Environmental Health Consultation Response		Officer	Heather Barton
Detail: Hybrid planning application for mixed use development comprising		Flare SRU:	042751
Address:	Clitheroe Road Whalley Clitheroe Lancashire		 <p>Ribble Valley Borough Council www.ribblevalley.gov.uk</p>
Application Ref:	3/2019/0545	Case Officer: Mr Adam Birkett	
Response Ref:	3/2019/0545/ENV/01	Issue Date: 19 November 2019

Figure 5 Façade reference mark-up

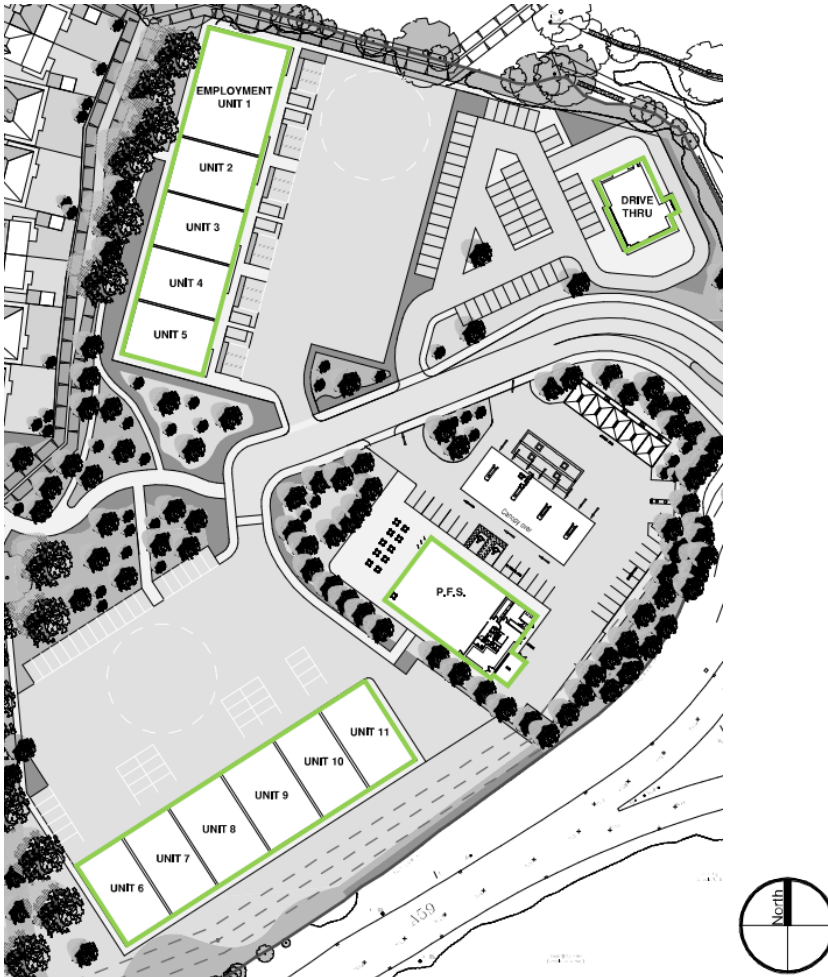
2.2	Ensure that the glazing within the residencies have sufficient noise reduction
2.3	Provide screening to the residences that are adjacent to the edge of the A59

Figure 6 Daytime noise levels across proposed site (1.5m above the ground) - dB $L_{Aeq,16h}$

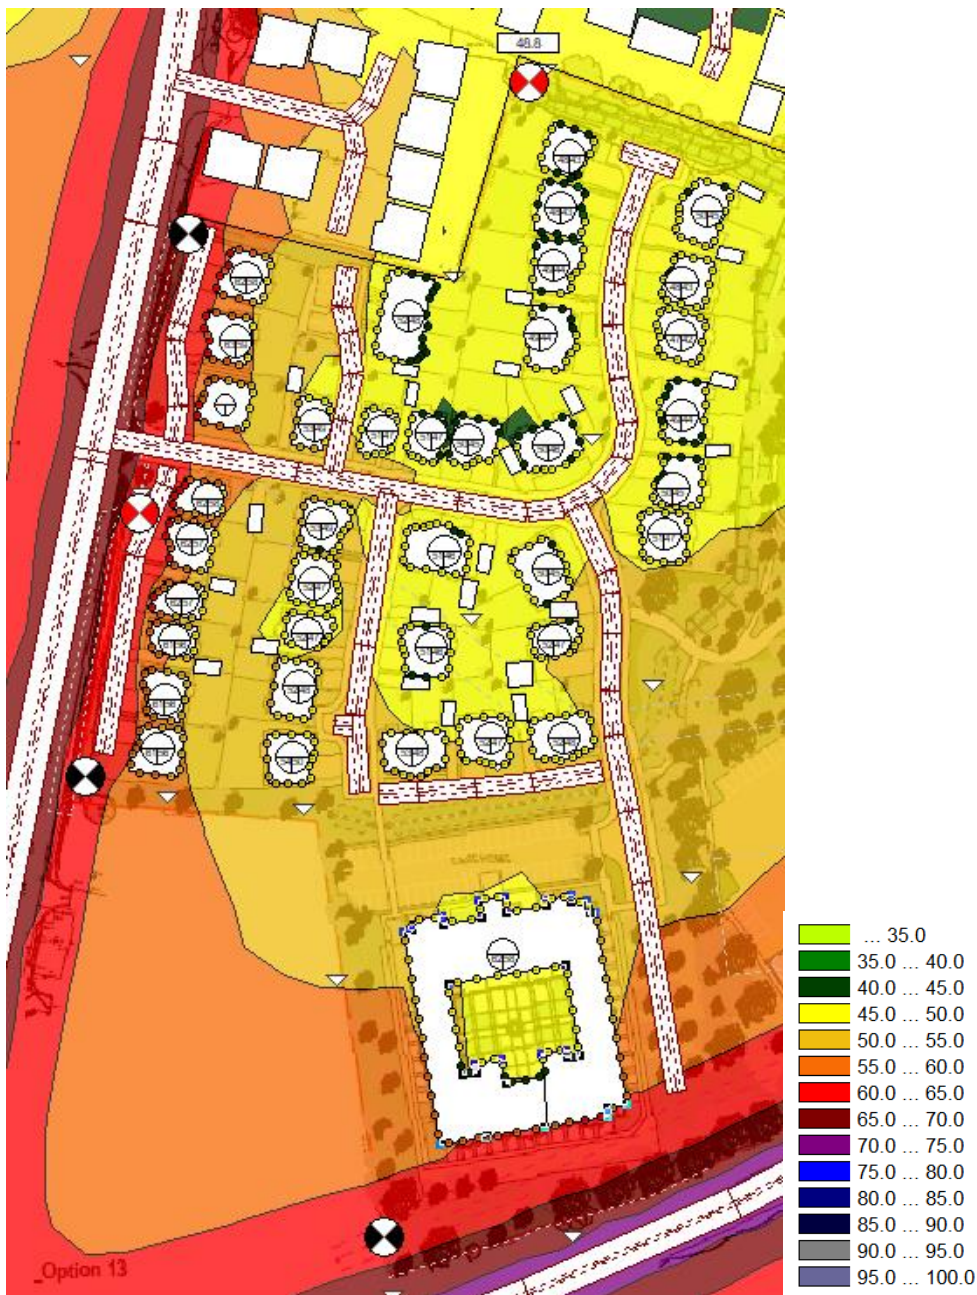
General Comments/Observations	
1.1	The noise survey indicates higher than average levels in properties with the windows open
1.2	The Noise survey indicates that the noise levels externally will be higher than average externally

1.3	The A59 is at a higher elevation than the residence – therefore noise levels higher
1.4	No recommendations for hours of use have been supplied in the noise assessment for the development
